OXFORDSHIRE COUNTY COUNCIL'S RESPONSE TO CONSULTATION ON THE FOLLOWING DEVELOPMENT PROPOSAL

Application no: 22/02025/REM

Proposal: Reserved Matters to 16/02586/OUT - Access, layout, scale, appearance and landscaping details for Phase 1B for up to 12 No knowledge economy units in Use Class E (former Use Class B) (14,972 sq m gross external area) with associated parking, landscaping, utilities and access

Transport Schedule

DRAWING NUMBER: **226701_PD01** REVISION: .

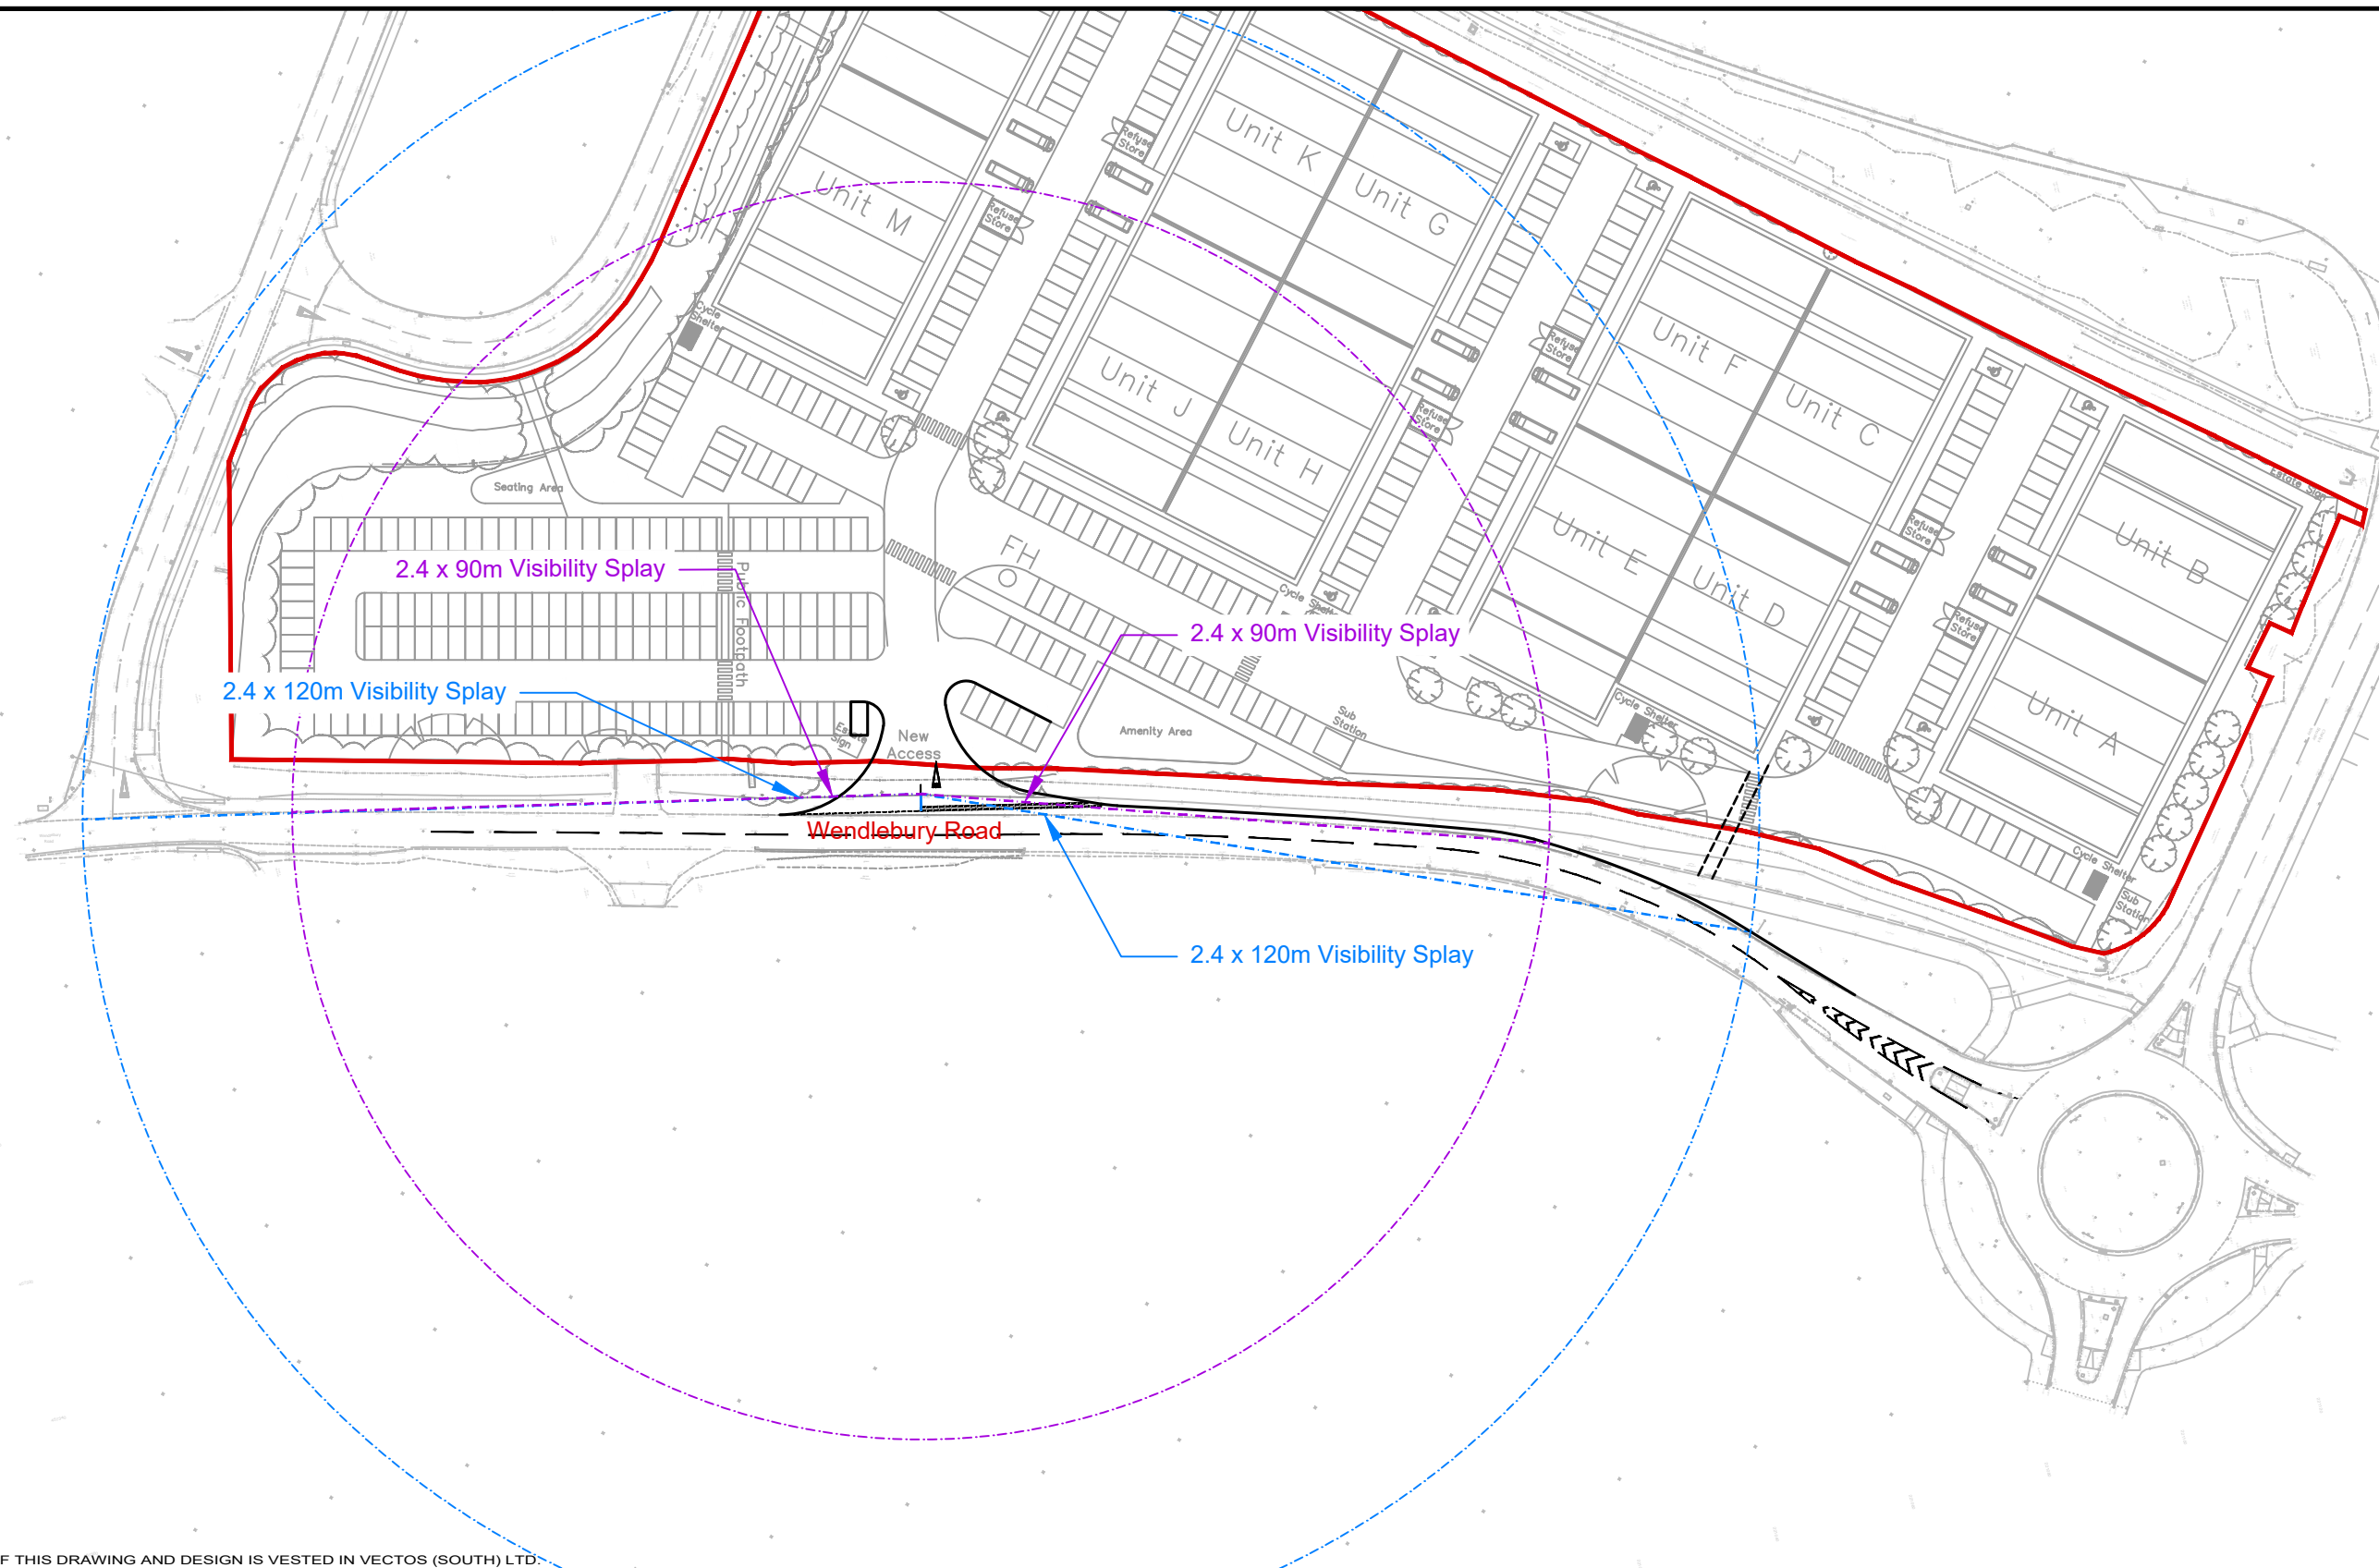
The cycleway should be extended out past their bellmouth to get cycles off carriageway sooner and have their bellmouth as a set back cycle crossing in line with LTN1/20.

HGV tracking should be provided for entrance and exit of site. **Reason for objection.**

the 30mph speed limit reduction will require extension and TRO to incorporate the new access and visibility splays. **Reason for objection.**

There are no visibility splays indicated. Junction and Forward Visibility Splays and dimensions must be in accordance with DMRB and dedicated to OCC if they fall out of the existing highway boundary. **Reason for objection.**

An obligation to enter into a S278 Agreement will be required to secure the new access off Wendlebury Road as set out in Vectos drawing No.226701_PD01, together with the extended cycleway as noted above under Road Agreements.
